AH/220010/L0003

**On behalf of Kier PGIM Logistics Propco 1 Limited, Saltbox, Bognor Regis:
Non-material amendment to reserved matters approval BE/121/21/RES - Alterations to
approved external appearance and roof of Unit 3**

The detail of the change sought is shown on the enclosed drawing KP281-Plot 3-NMA-01 prepared by Ian King Associates. This shows revisions to the elevations of Unit 3 in response to the requirements of the intended tenant and changes to the associated materials to correspond with Kier's specification for the site.

Roof plan

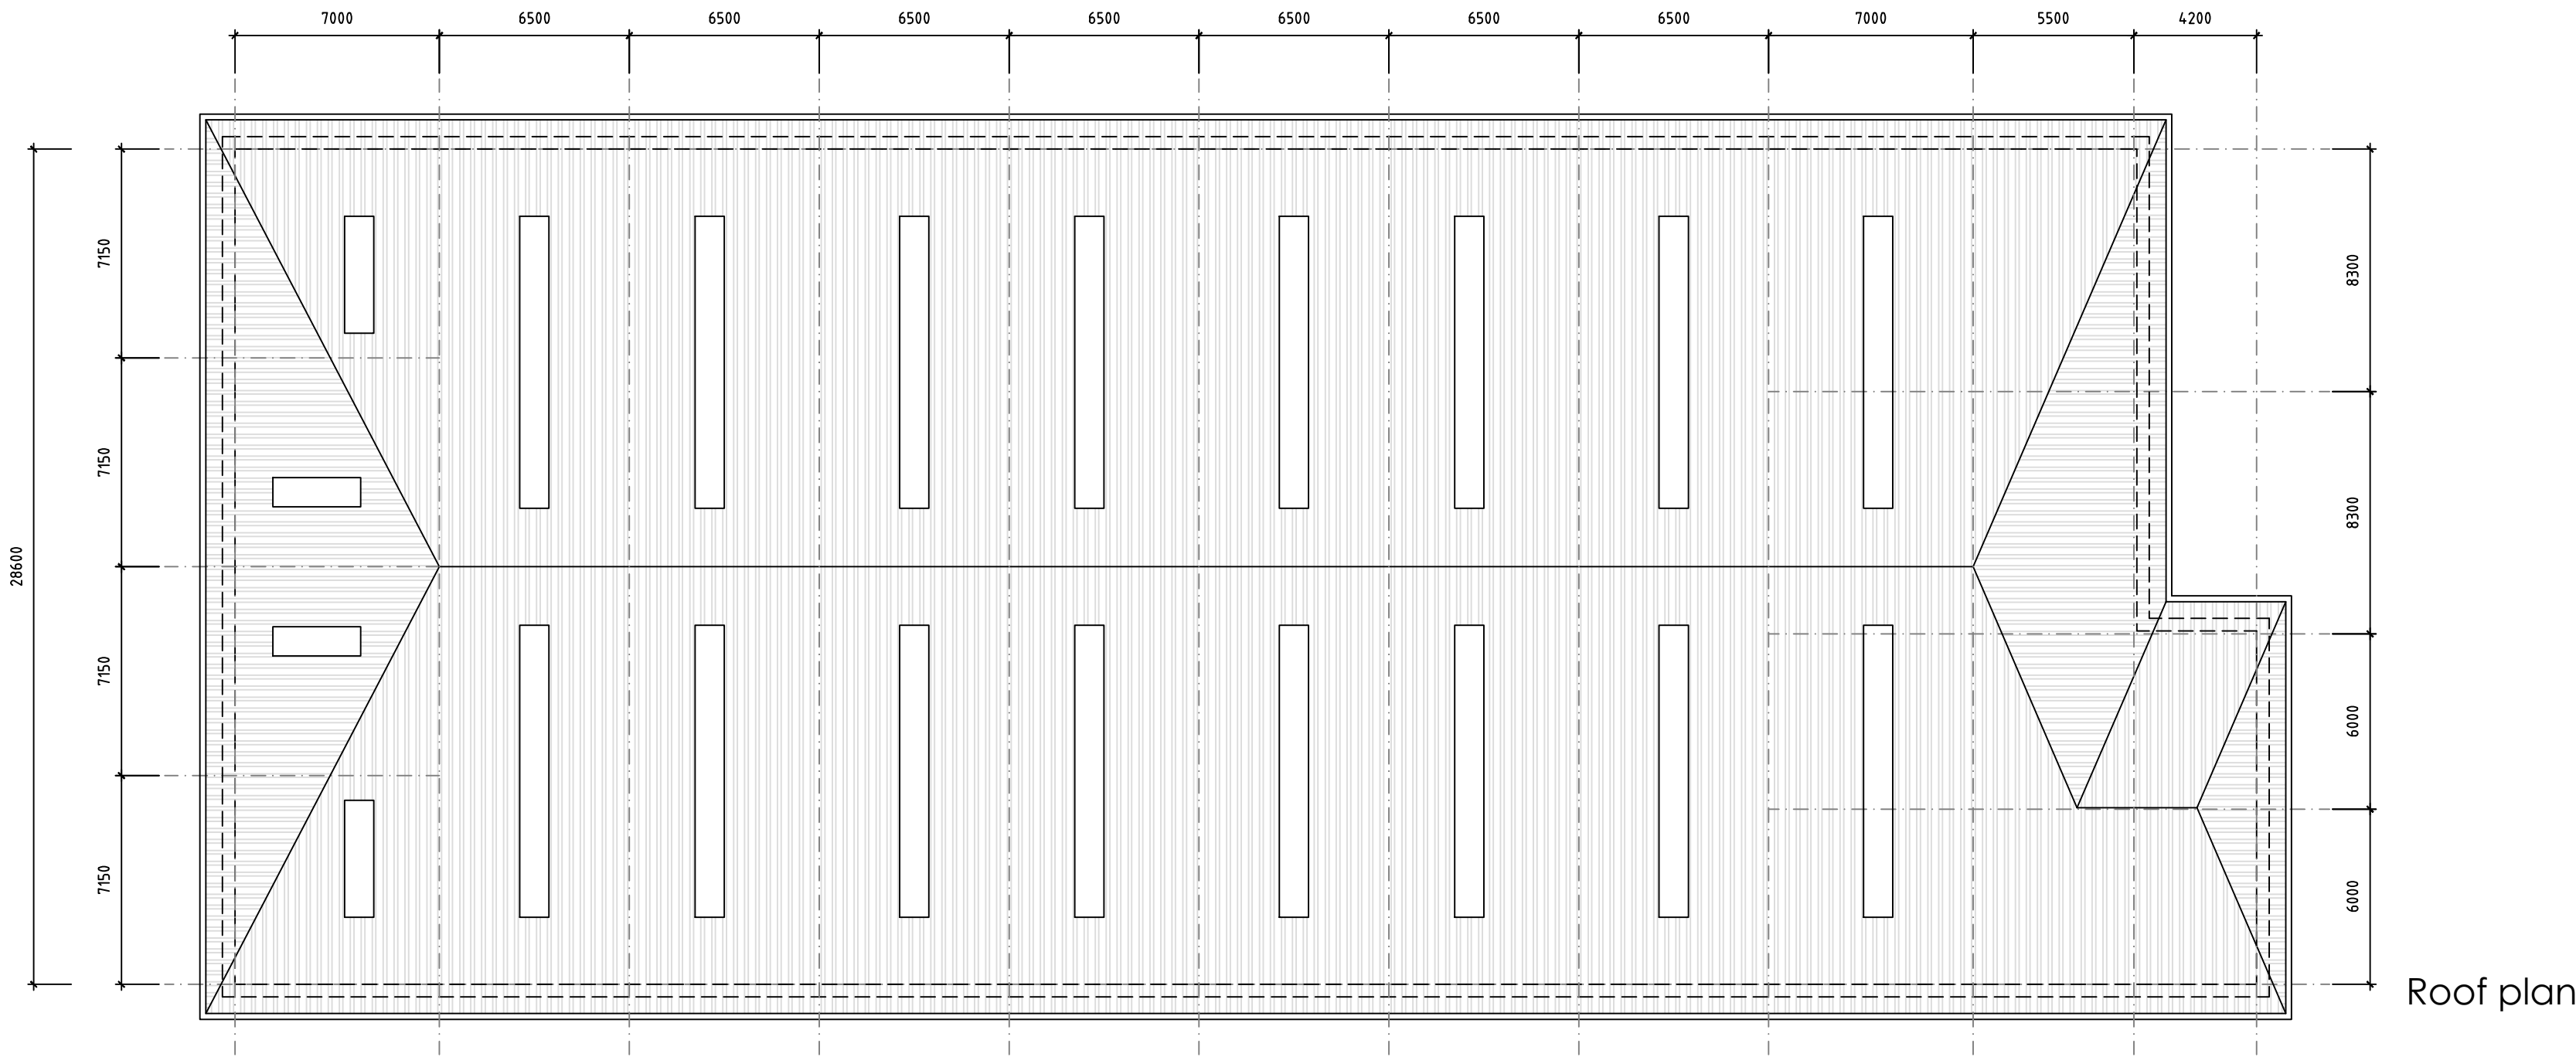
A minor change is also proposed to the roof of Unit 3 to incorporate hip features at the western and eastern ends. This will add interest to the building's appearance and will also serve to reduce its overall scale and massing.
